M/38/19/DOC

Picture – 'Goodwood Dark Clamp' bricks.

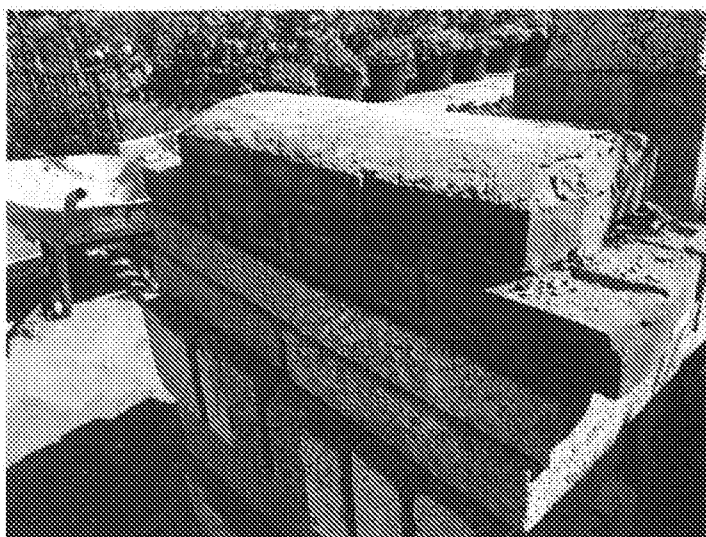
The proposed materials and bonding appear to be acceptable. If the application had been submitted at the appropriate time, a lighter coloured mortar would have been considered to reflect that used within the existing flint and brick walling.
